ALAPPAHO SHOP DRAW. - STREETSCAPE

DATE	5-12-99	JOB NO.
ATTENTION		
RE:	Arapaho Rd	
	Bollards

Re Arapaho Road – Bollards

Mr. James C. Pierce, Jr., P.E.  
Assistant City Engineer  
Town of Addison  
P.O. Box 144  
Addison, Texas 75001Re: Arapaho Road Reconstruction  
Addison Road to Dallas North Tollway  
Town of Addison

**(B) CUSTOM CONCRETE BOLLARD**

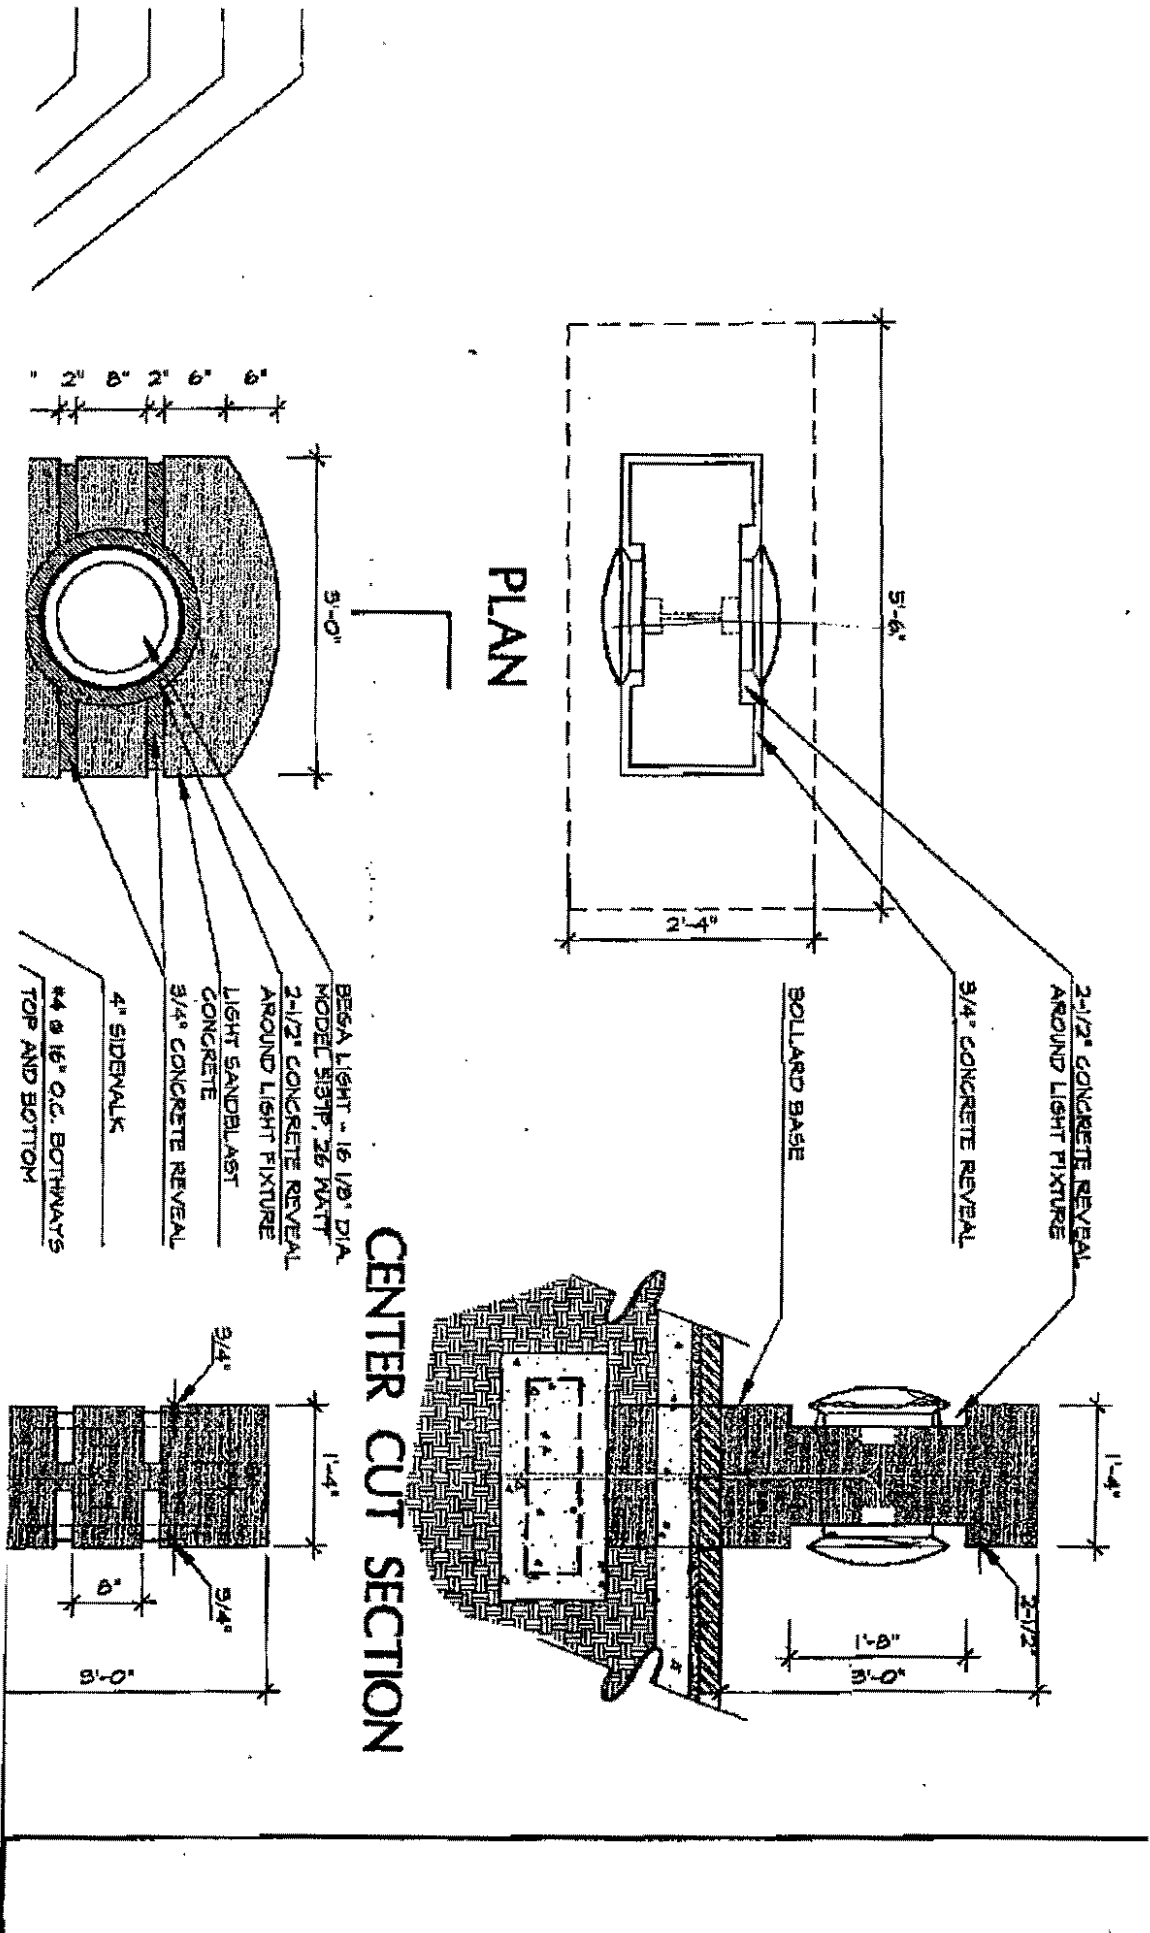
*Sample bollard is approved. However more quality control is needed to limit patching. Too much patching will be grounds for rejection*

On March 24, 1999 we approved a shop drawing for the bollards. We see no need to pay an additional \$800.00 per bollard. If it would help, we would be willing to forego the rounded top and the ¼" chamfer on all outside edges as long as the overall height is 3'-10".

Our bollard subcontractor has reviewed the revised detail for the bollards designated for installation around the Quorum/Arapaho intersection. Based upon the modifications, they will need an additional \$800.00 per bollard making the new price \$3,500.00 per bollard. Once the decision regarding these bollards has been finalized, the bollard manufacturer will need a minimum of four weeks to manufacture a sample and make the full production run of 16 bollards.

Color to match sidewalk  
Sandblast Finish
